Consultation Response from KC, Highways Development Management
2023/93388 Dene End Funeral Home, 50, North Road, Kirkburton, Huddersfield, HD8 0RW
Change of use from domestic to commercial, demolition of existing workshop and erection of three storey office building (within a Conservation Area)
Date Responded: 20-3-2024. Responding Officer: Mark Berry. Responding Ref: 12-42-9.

DRAWING TITLE
CONSTRUCTION MANAGMENT PLAN

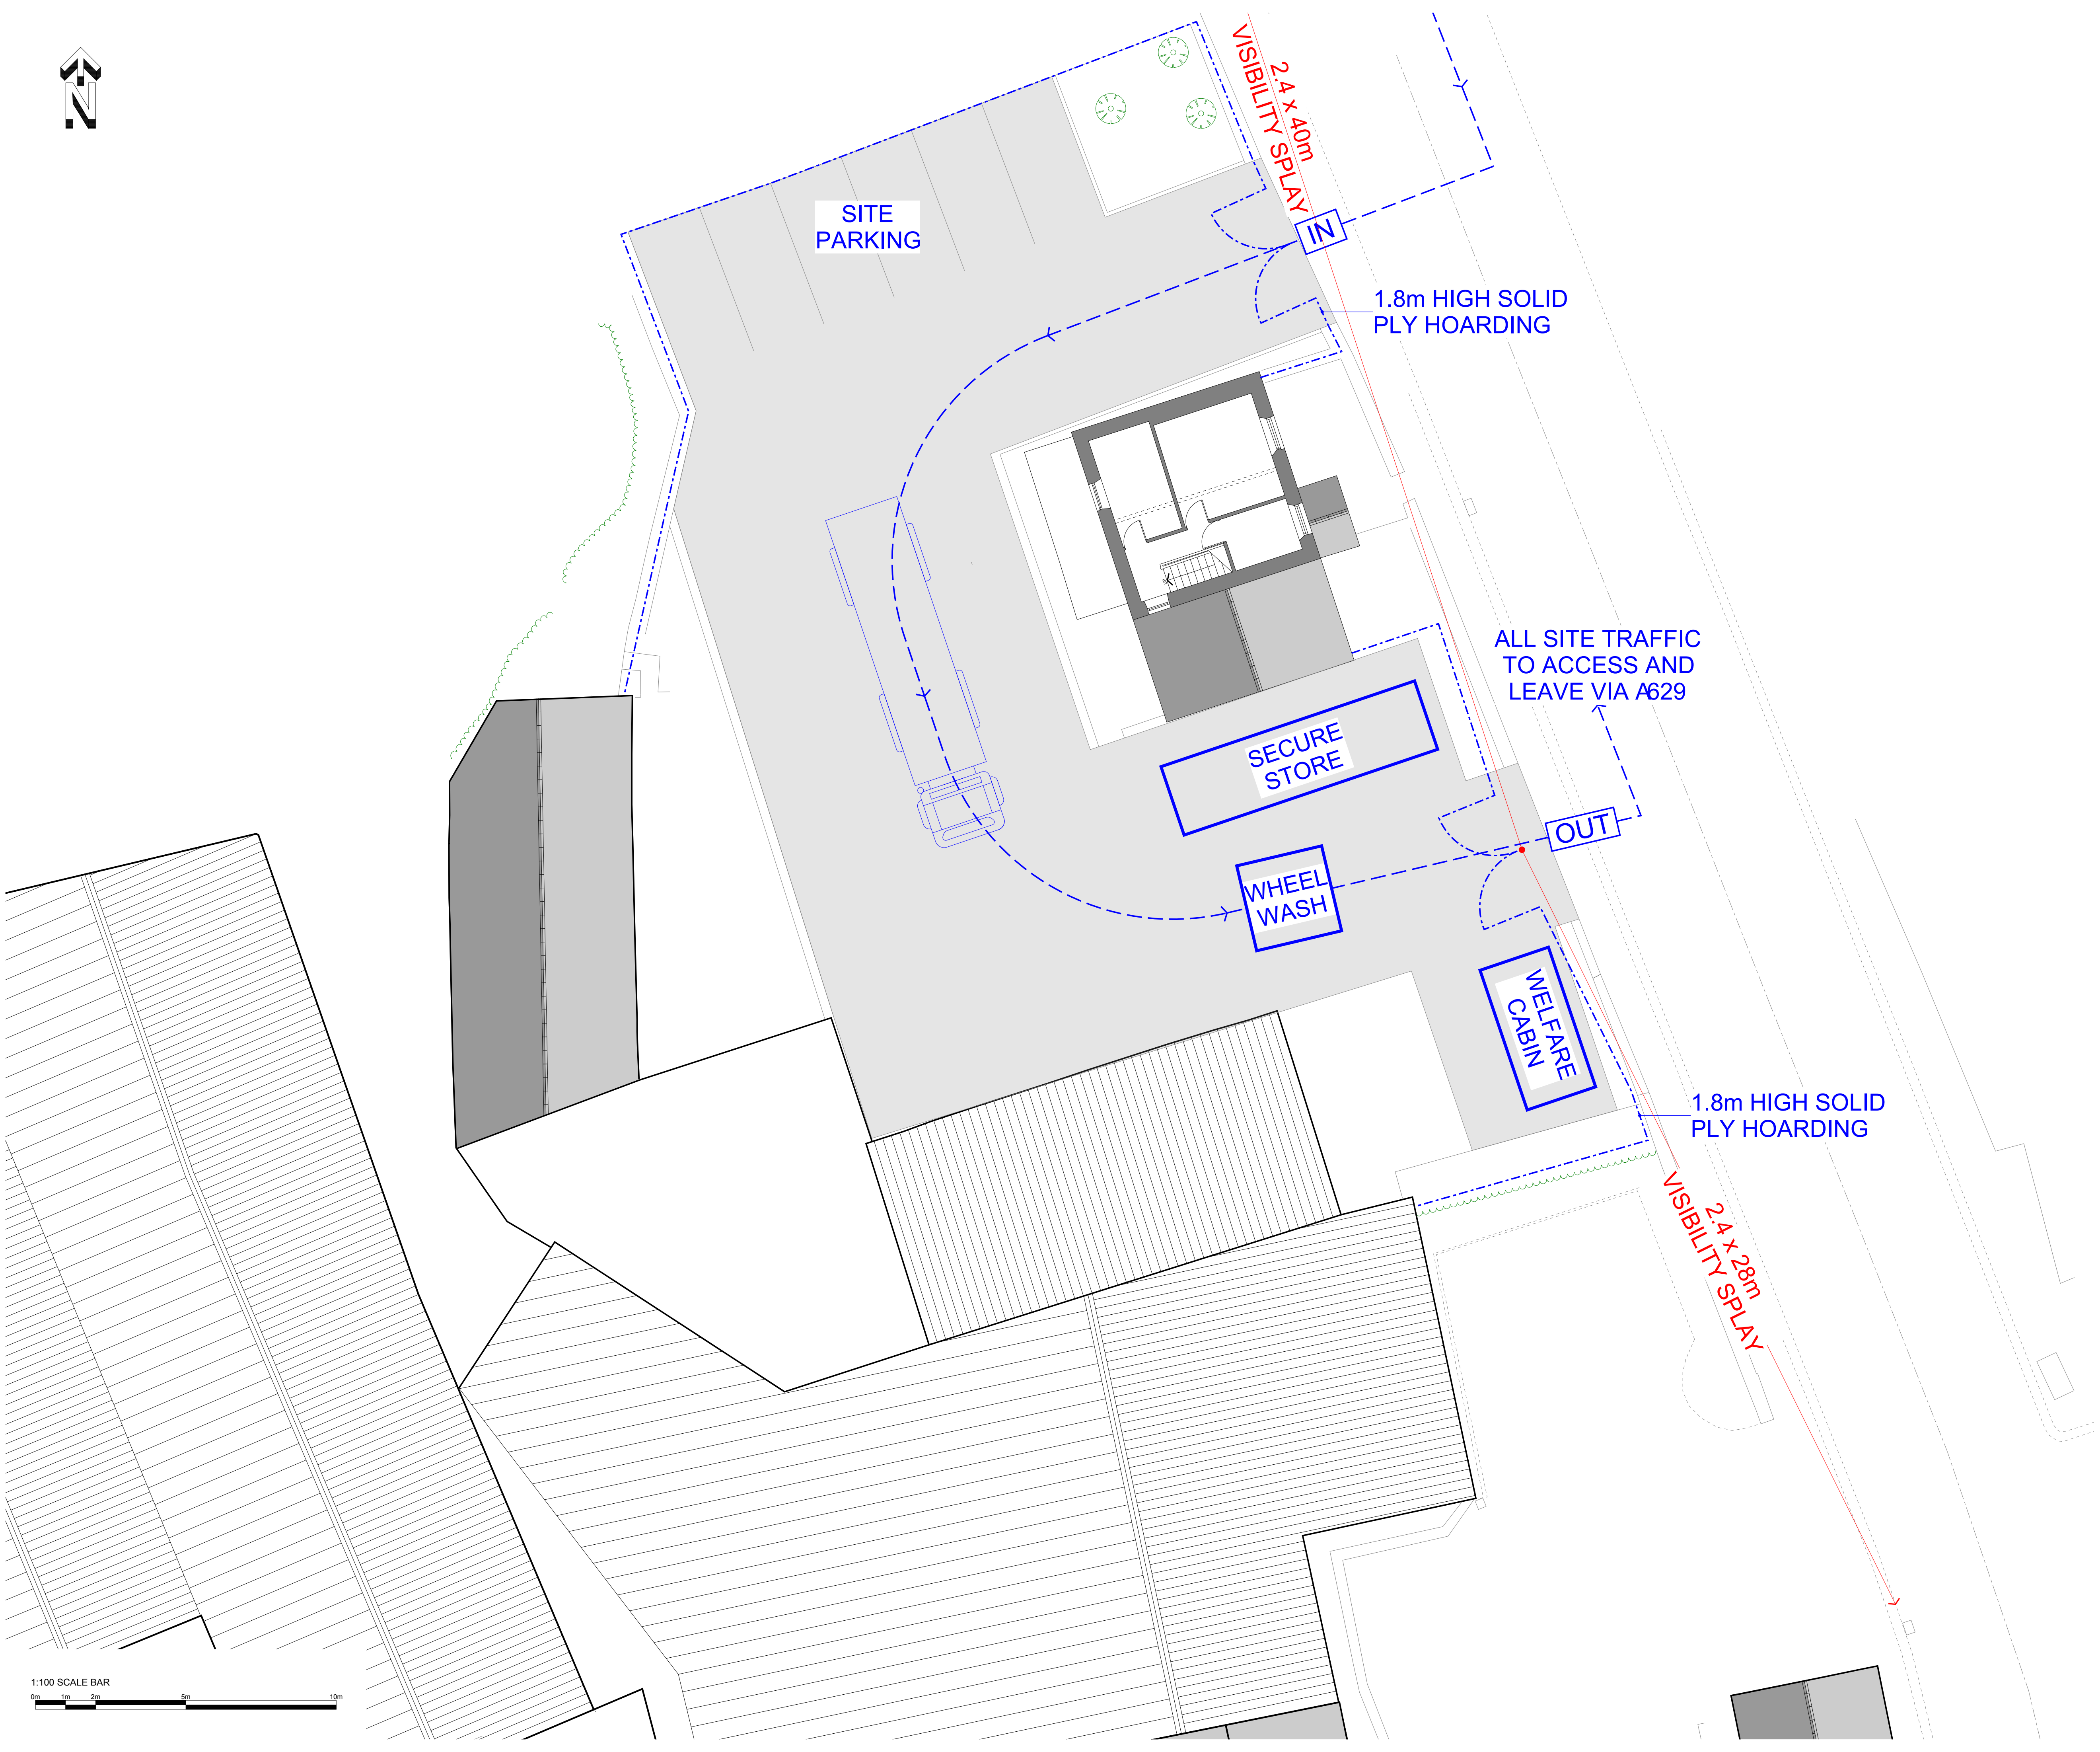
Prior to construction commencing, a schedule of the means of access to the site for construction traffic shall be submitted to and approved in writing by the LPA. The schedule shall include the point of access for construction traffic, details of the times of use of the access, the routing of construction traffic to and from the site, construction workers parking facilities and the provision, use and retention of adequate wheel washing facilities within the site. Unless otherwise agreed in writing by the LPA, all construction arrangements shall be carried out in accordance with the approved schedule
